Article 21 of the Town and Country Planning (General Development Procedure) Order 1995
Application for approval of details reserved by condition 5 of previously approved planning
application EP/128/09 - relating to bin and cycle storage
Stoney Beach Cottage South Strand, East Preston, Littlehampton

Arun District Council have decided to **REFUSE details reserved by condition for the following reasons:**

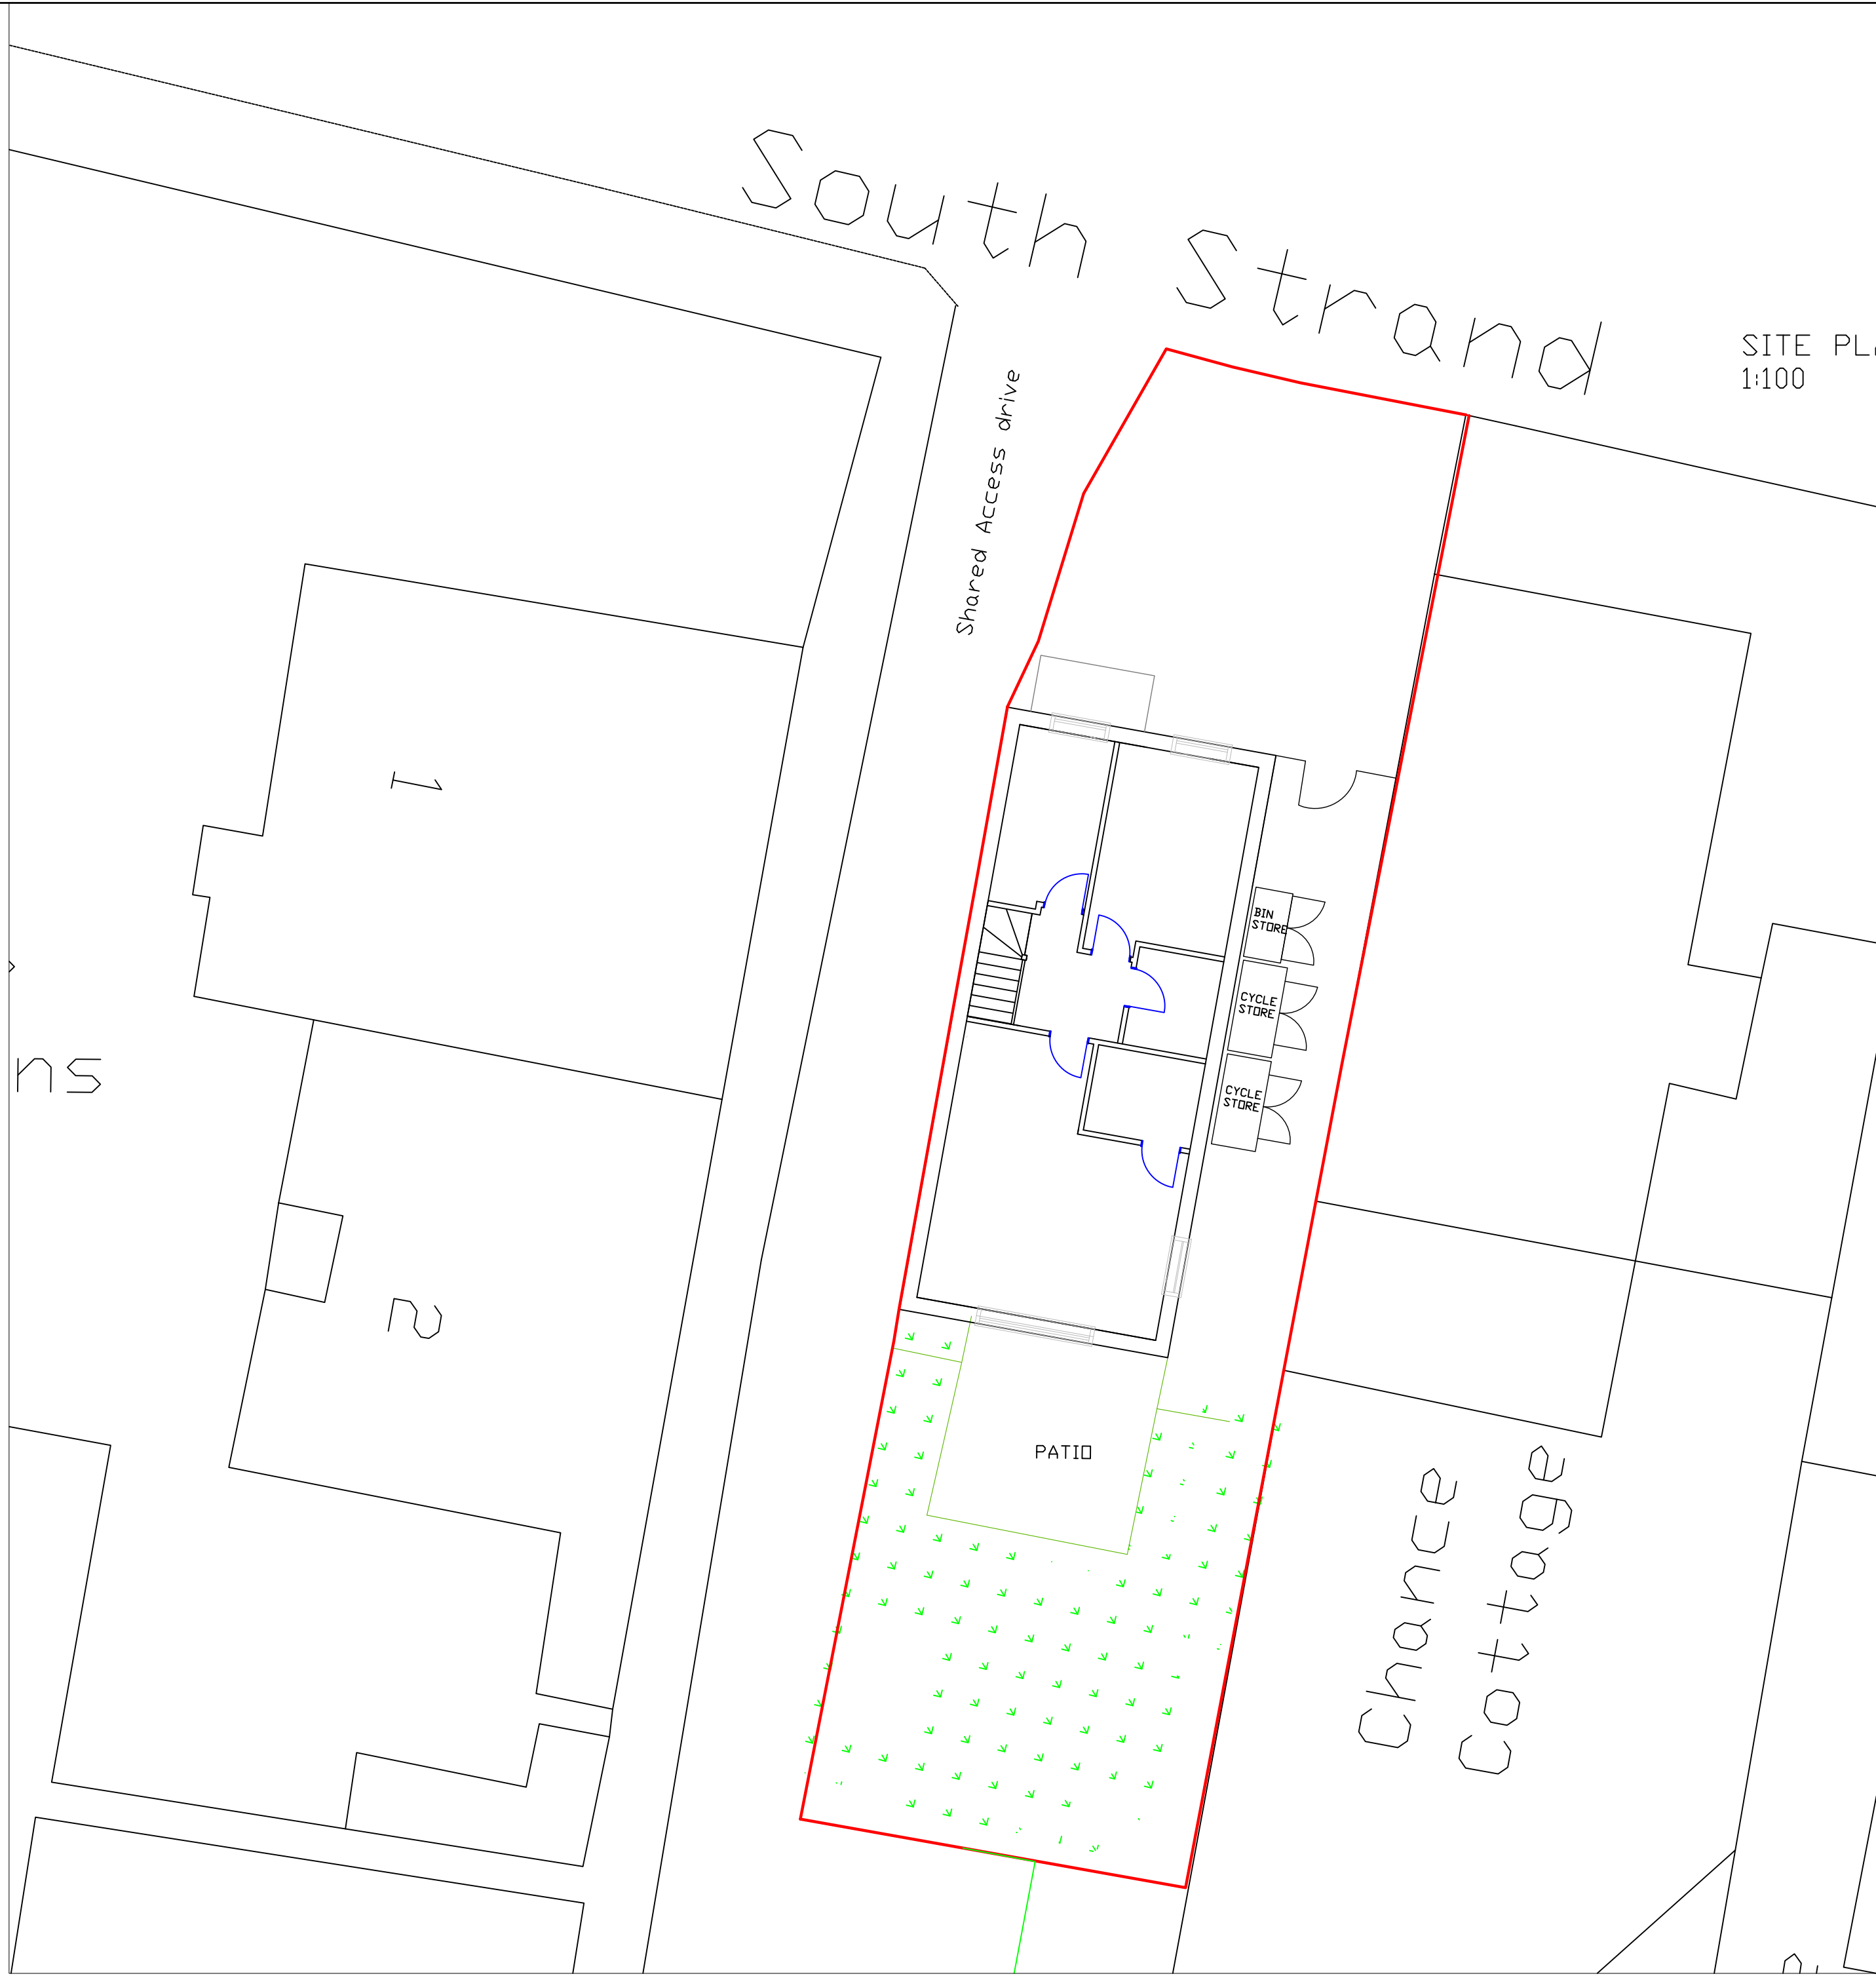
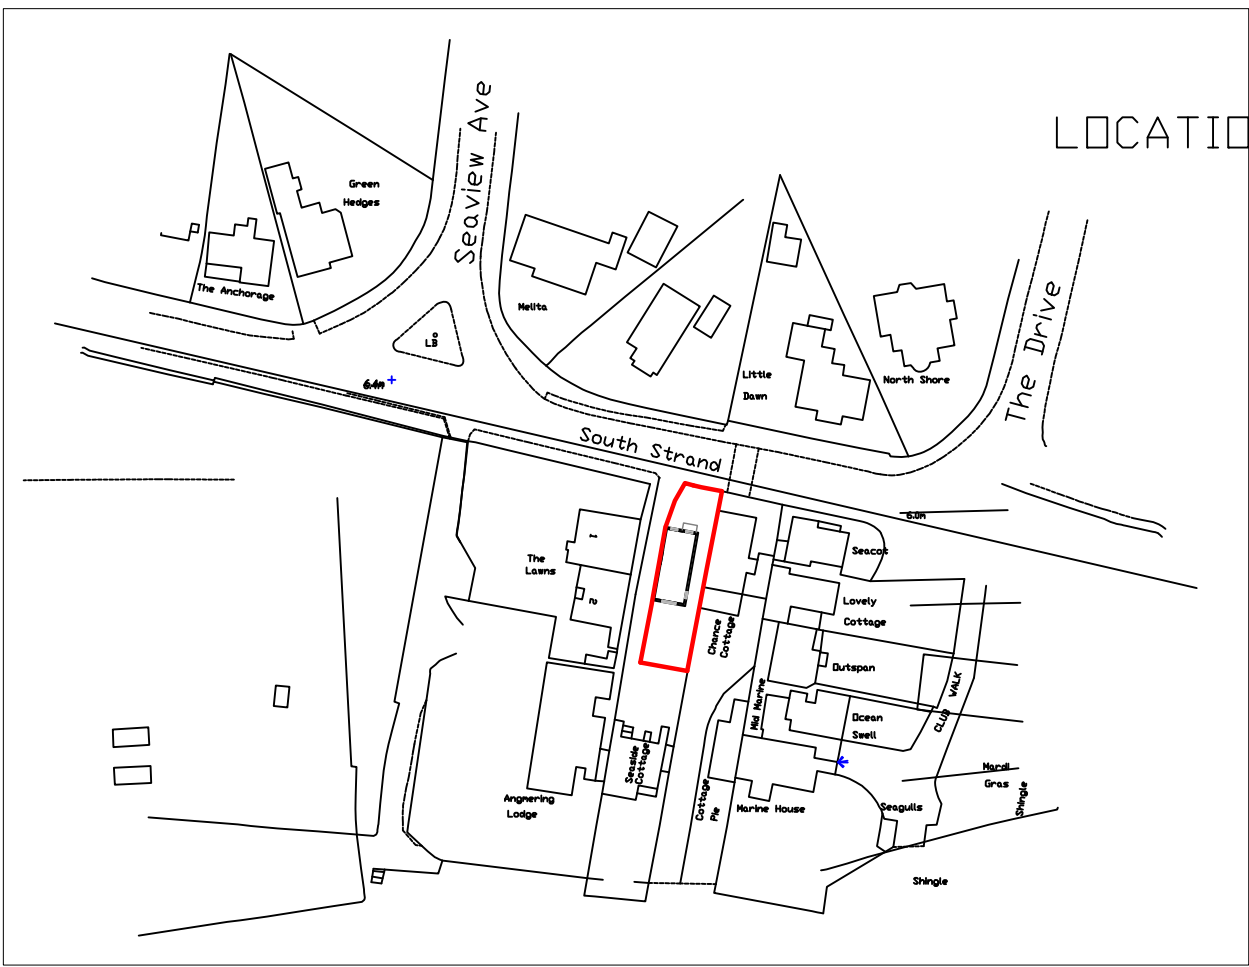
The position of the cycle and bin store is not the same as that approved under EP/92/14/DOC and the submitted details are not therefore in accordance with the wording of the condition which refers to 'details of the bin and cycle storage shown on the submitted plan'.

Should you wish to pursue this amended layout then a revised application for planning permission will need to be submitted for consideration.
